# Rezoning Transportation Analysis

Petition Number: 2020-134

**From: Robyn Byers, PhD**  
[Robyn.Byers@charlottenc.gov](mailto:Robyn.Byers@charlottenc.gov)  
704-336-7404

**Reviewer: Kevin Parker, PE**  
[Kevin.Parker@charlottenc.gov](mailto:Kevin.Parker@charlottenc.gov)  
704-432-6511

RZ-1.0

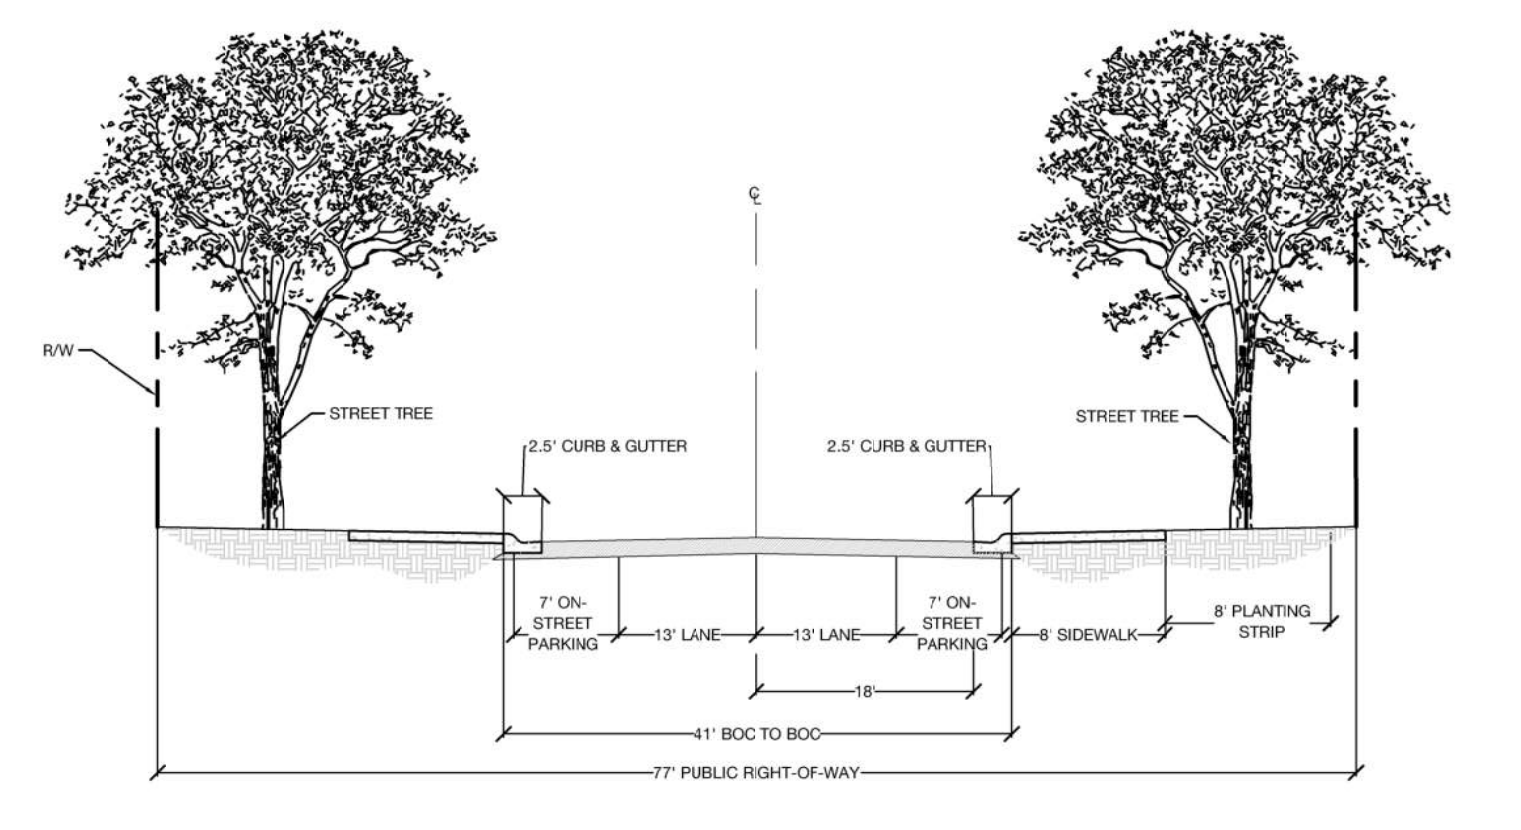
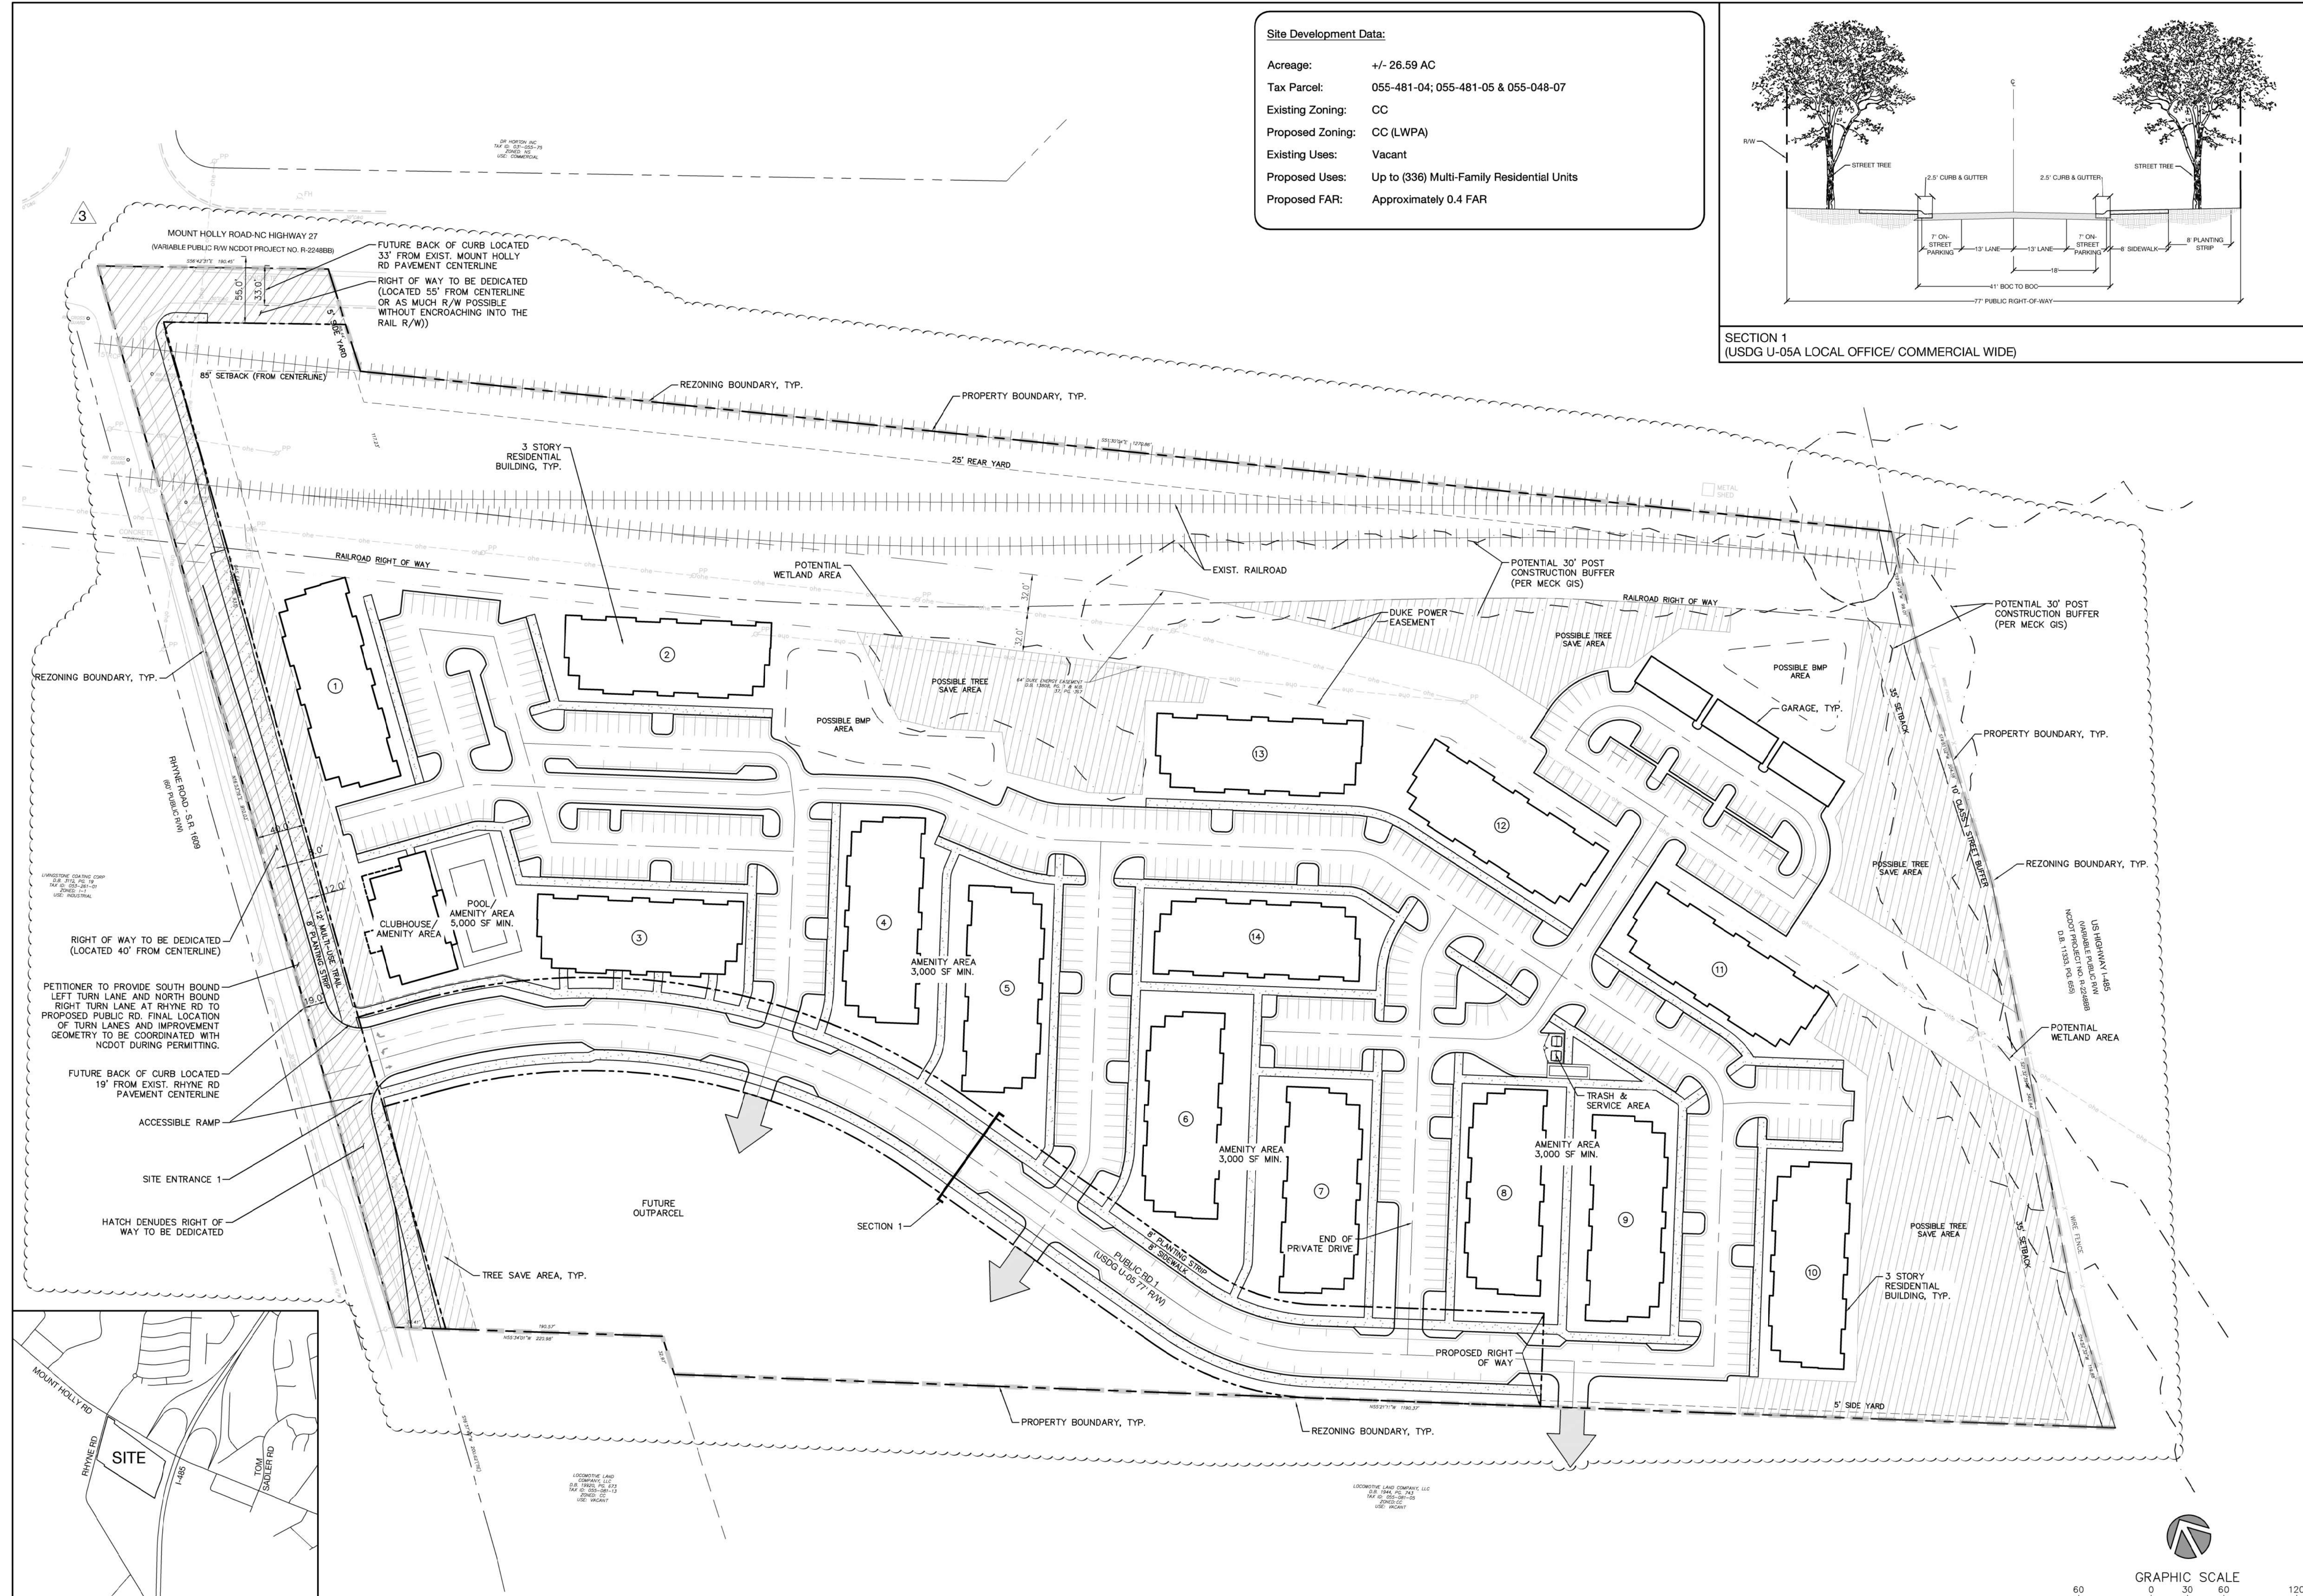
- a. ~~Mt. Holly Road:~~ The future location of curb and gutter will be located 33-feet from centerline to the back of curb.
- b. ~~Rhyme Road:~~ The location of curb and gutter will be located 19-feet from centerline to the back of curb.

Label and dimension the curb and gutter from the centerline for each road.

- a. ~~Mt. Holly Road:~~ Revise the site plan and conditional note(s) to commit to dedicate 55-feet of right-of-way from the road centerline. **Update as a result from 11-16-2020 Site Plan:** Dedicate as much ROW as possible without encroaching into the Railroad ROW.

The site plan should label and dimension the right-of-way from the road centerline.
